Please upload the email below which is a further consultation response from **ADC Drainage Engineers** to discharge of condition application **LU/90/20/DOC** – Hampton Park.

Paul Cann
Principal Engineer (Drainage)

Title: **General Engineering Plan Sheet 2 of 2**

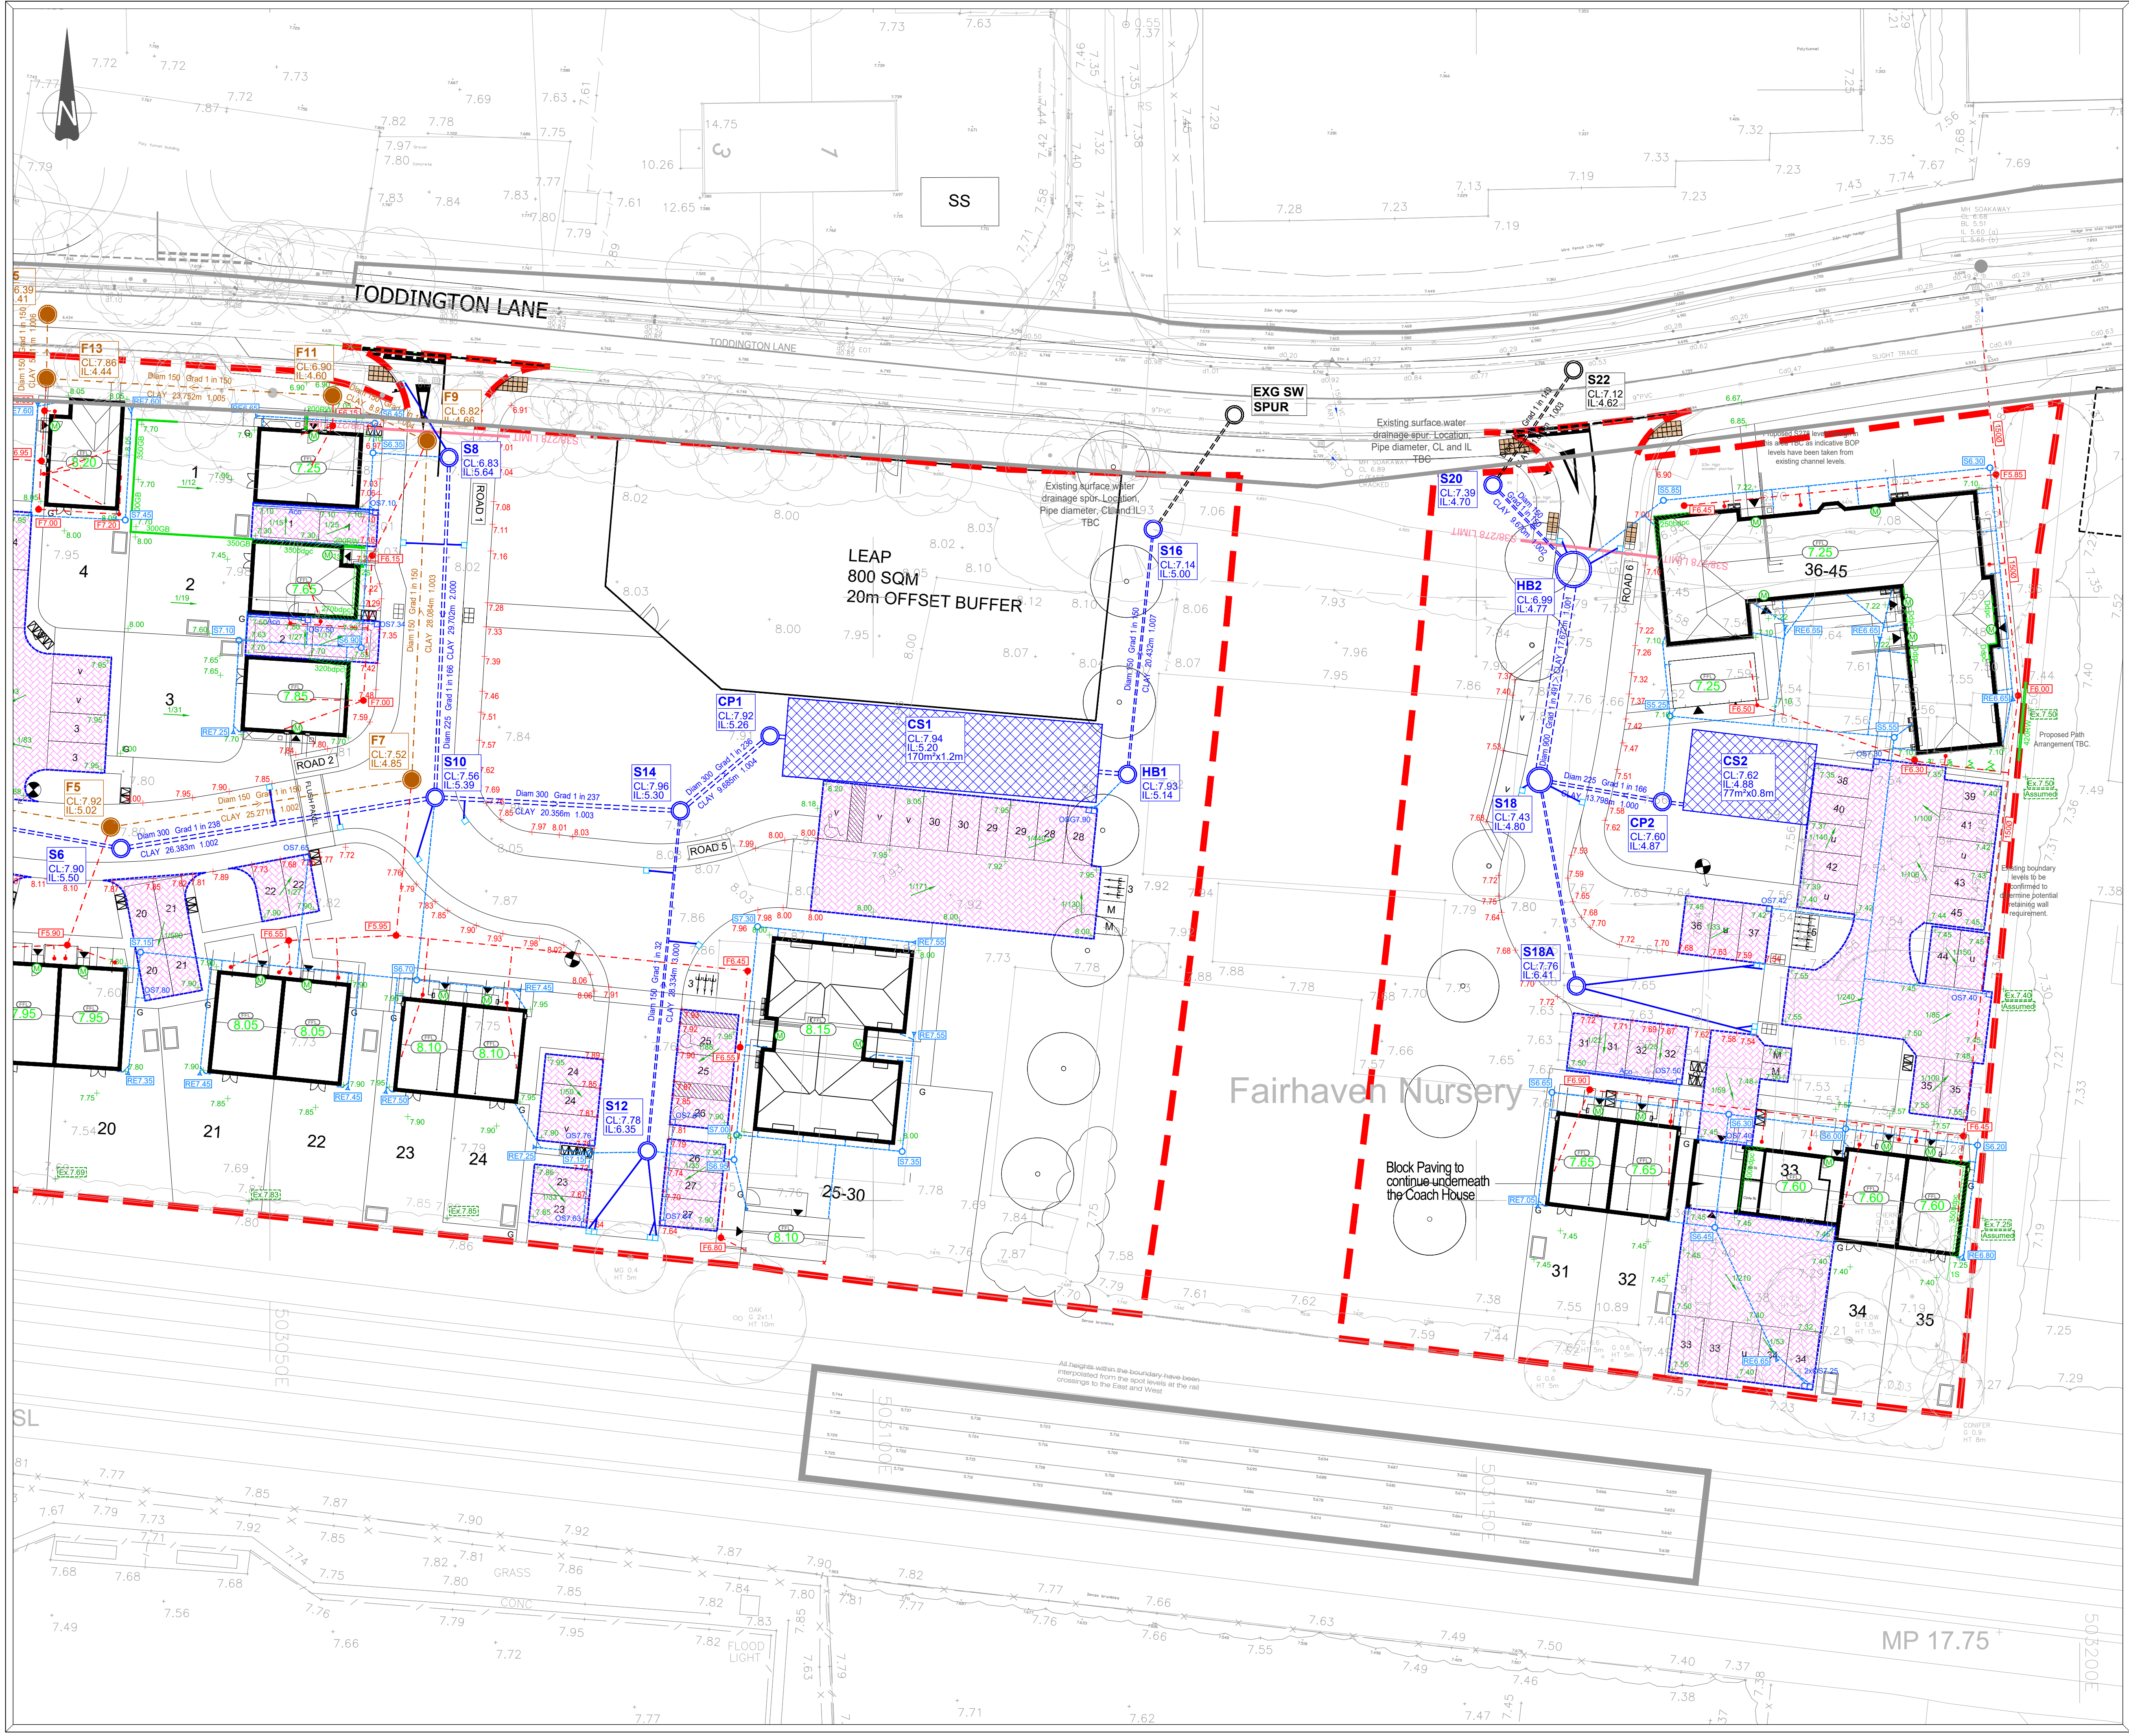
6. Both hydrobrake chambers – show base thickness/reinforcement details.
7. Existing manhole SW03A – just upstream of SWA2_01 – what is its purpose? Invert level is lower than the downstream manhole. Please clarify if it is required and adjust as necessary.

10. Drawing 122 shows a duplicate manhole downstream of immediately downstream of SWA2_01.
11. Show pipe gradients on all non-adoptable drainage.
12. Items 11 and 12 of my previous email – please advise where these notes have been added. Also, saddle connections were not requested and reference should be made to oblique 45 degree junctions.

Type B Manhole

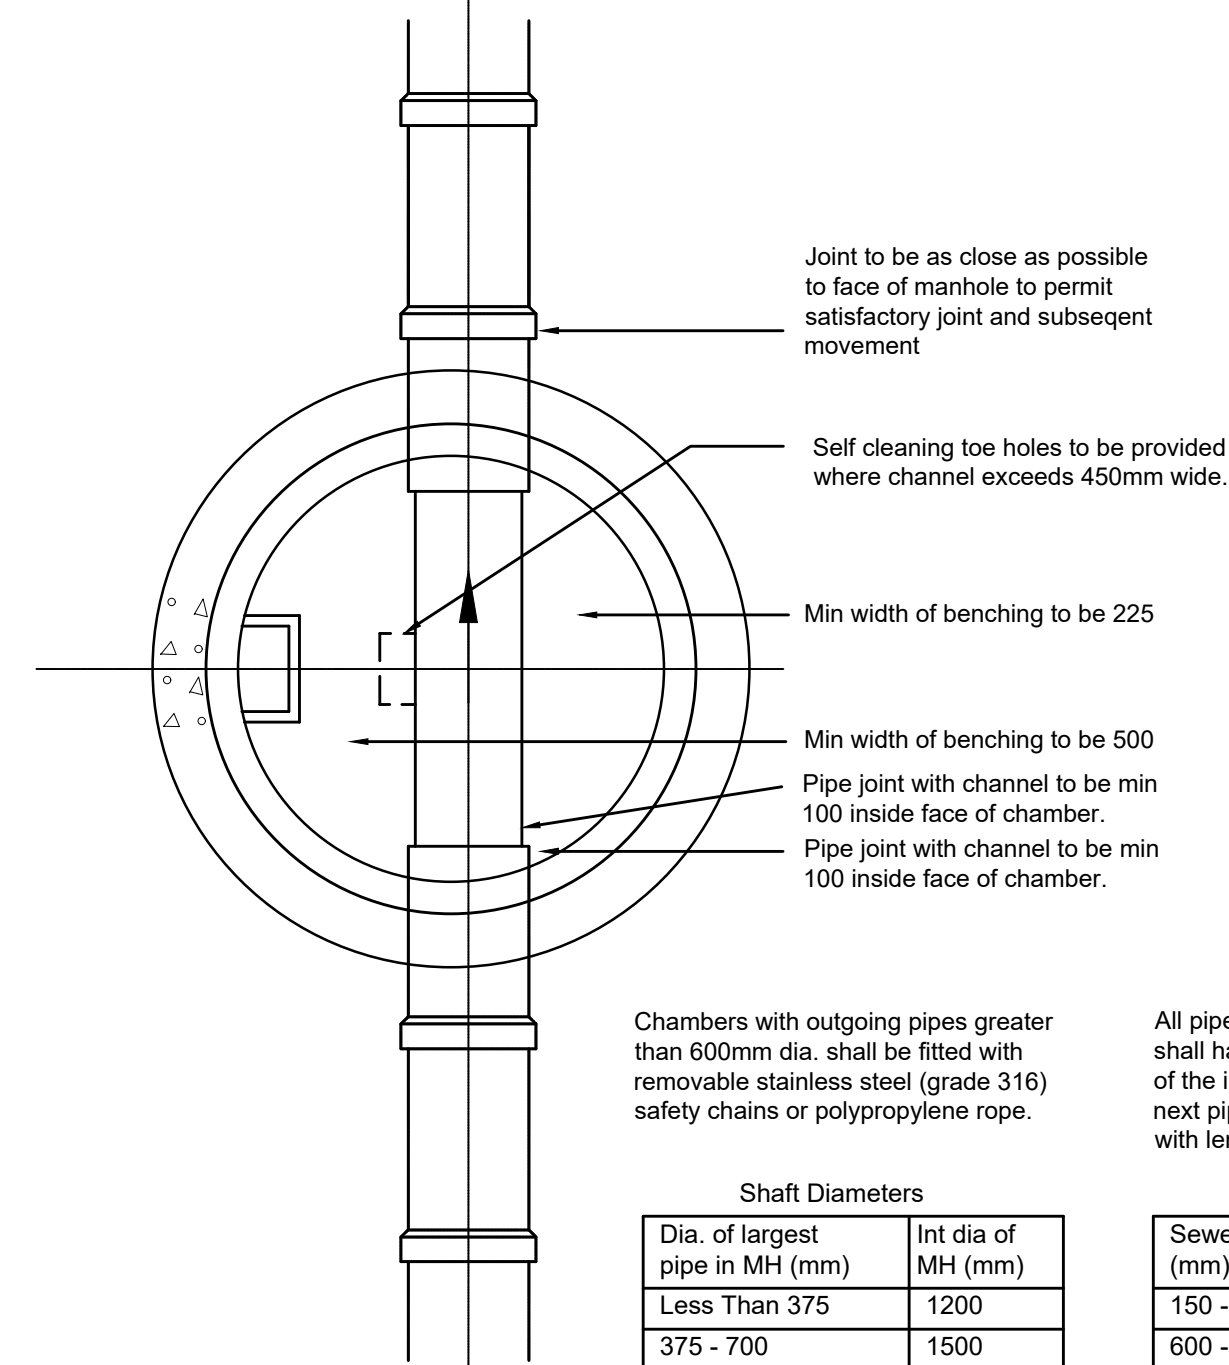
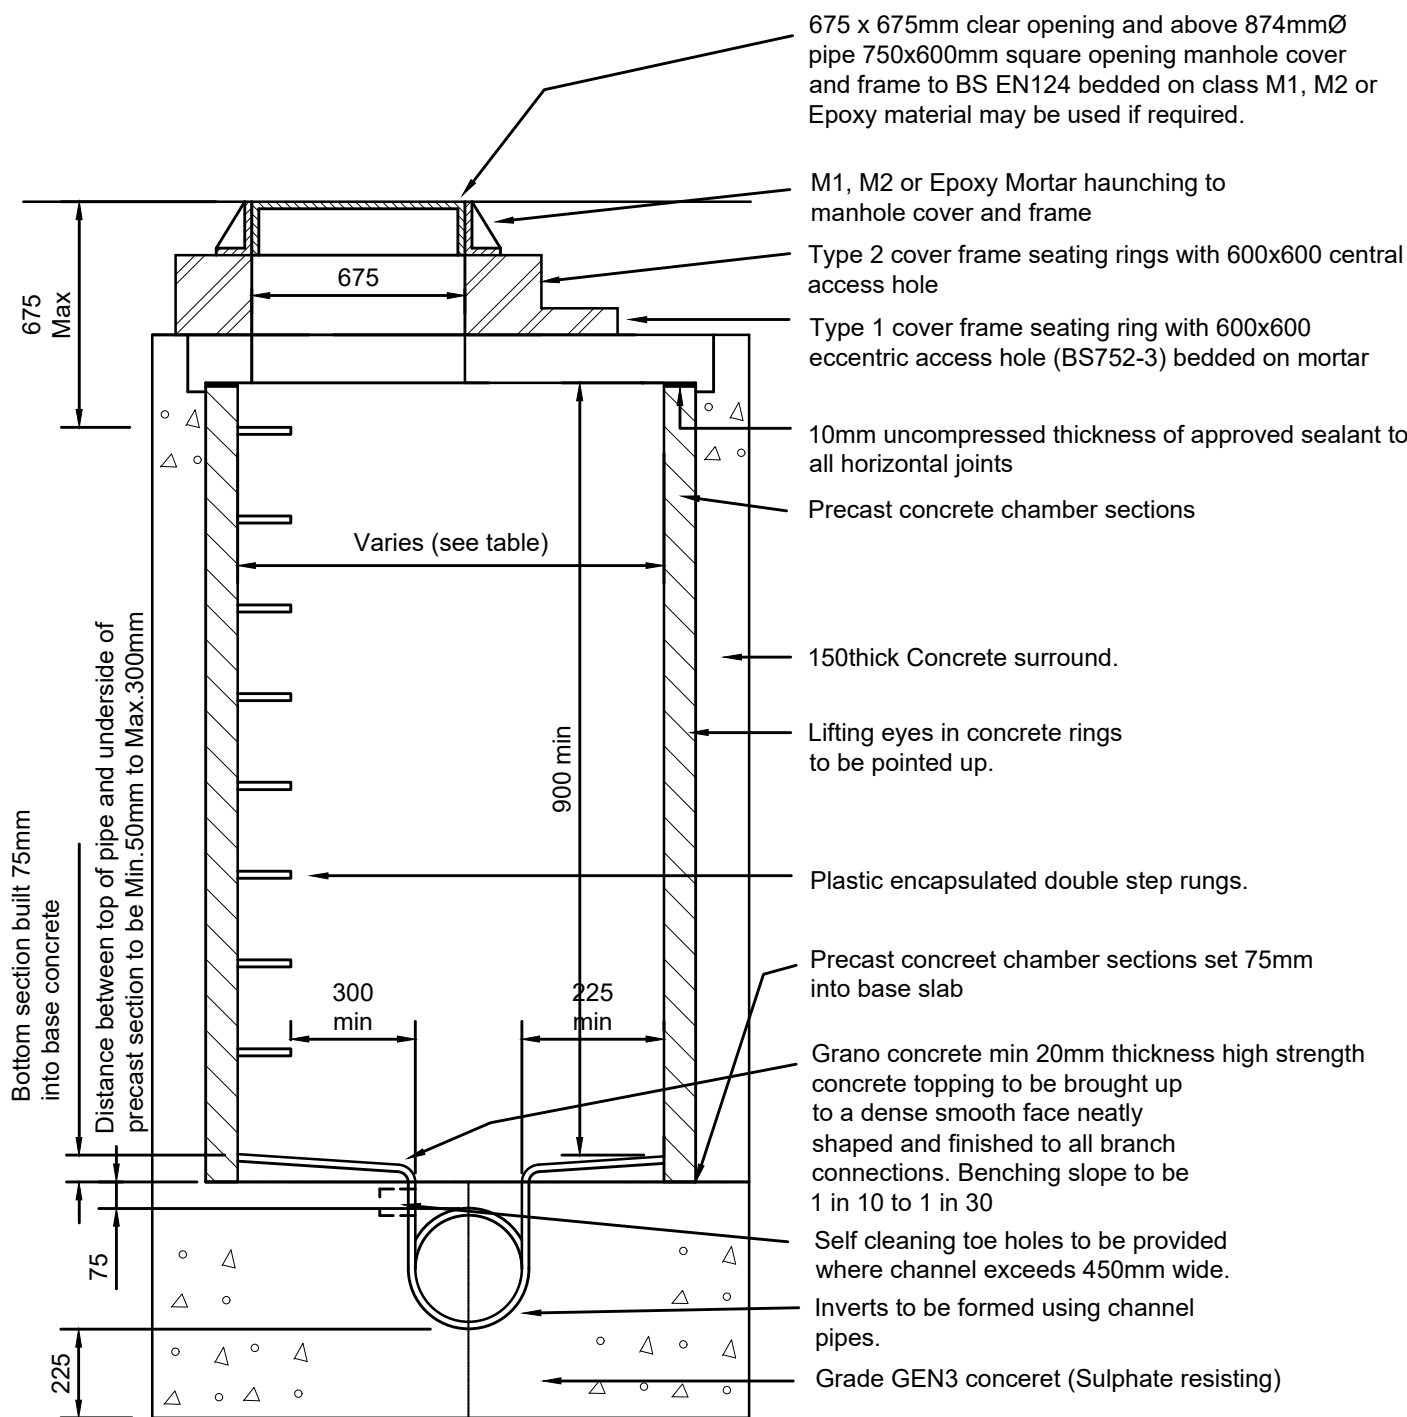
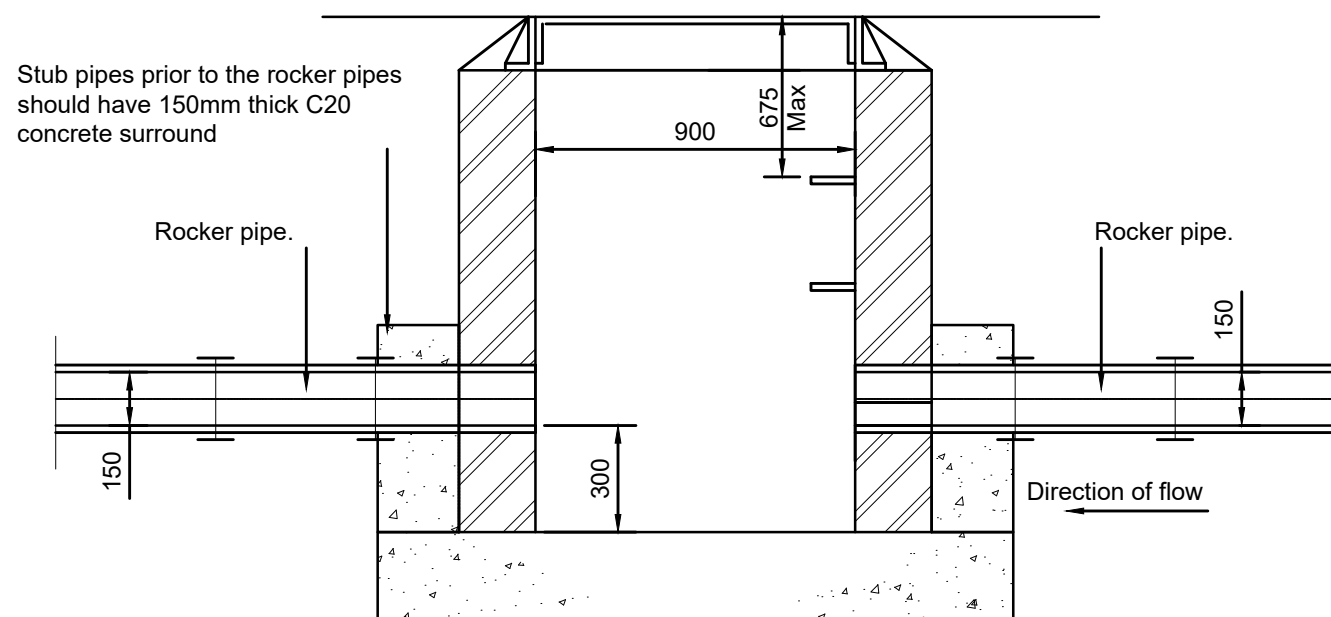
1. CP1 and CP2 (catchpits) on the manhole schedule drawing need to refer to a catchpit detail, not a type B manhole.
2. Provide non adoptable manhole construction details.
